OFFICE OF THE GENERAL MANAGER

21 July 2022

Subject: Gunlake Quarry Continuation Project (SSD 12469087)

A review of the response to submissions in relation to the above proposal has been undertaken and a report was considered at the 19 July 2022 Council Meeting. At this meeting, Council resolved:

APPENDIX 3: PRIMARY AND SECONDARY TRANSPORT ROUTE

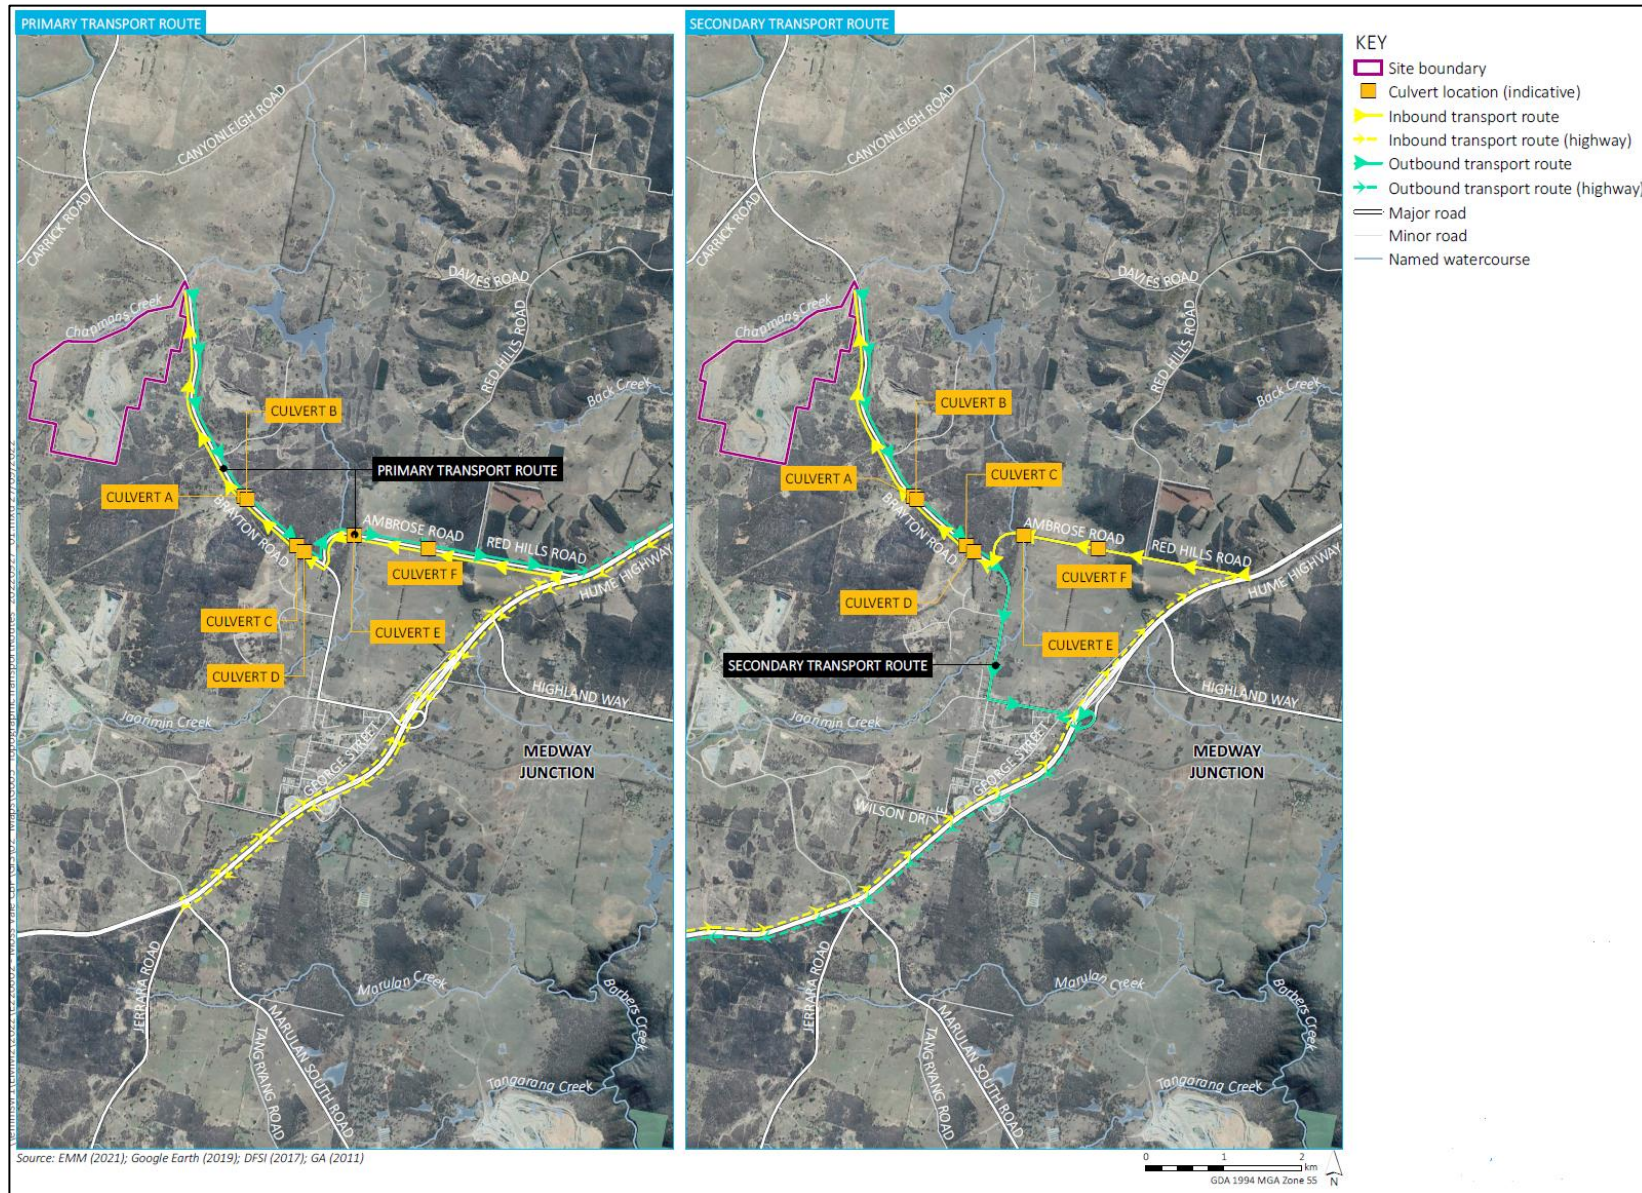
3. Council requires all actions identified in the Road Safety Assessment Report for the Primary Transport Route to be implemented prior to commencement of operations.

5. Any proposals for the future use of haulage trucks beyond the currently approved higher mass limit B-Doubles (25/26m) on the Primary and Secondary Haulage Routes will prompt a structural assessment of bridges and culverts along the Primary Transport Route.

6. GMC continue to advocate with Transport for New South Wales and the NSW Government Local Member of Parliament that the speed limit for the Primary Transport Route be reduced to 80km/hr for all vehicles.

- a. A 3m clear zone be implemented along the entirety of the primary haulage route, or alternatively the use of safety barrier in locations where this cannot be achieved, including a plan identifying when the works will be undertaken.

- b. Provision of a wide centreline treatment to the length of primary haulage route, including a commitment to upgrade all affected culverts (Culverts A-F). Prior to endorsement Council will require a written commitment from the applicant that identifies the timeframe in which the works are to be completed.

- c. Provision of documentation demonstrating that the pavement of the entirety of the haulage route (incl. the secondary haulage route) can achieve the required minimum 10 year expected lifespan. This documentation must include a desktop audit by an independent geotechnical consultant (of whom the appointment will be made upon the agreement of Council and the applicant) to validate the methodology used to determine pavement life.
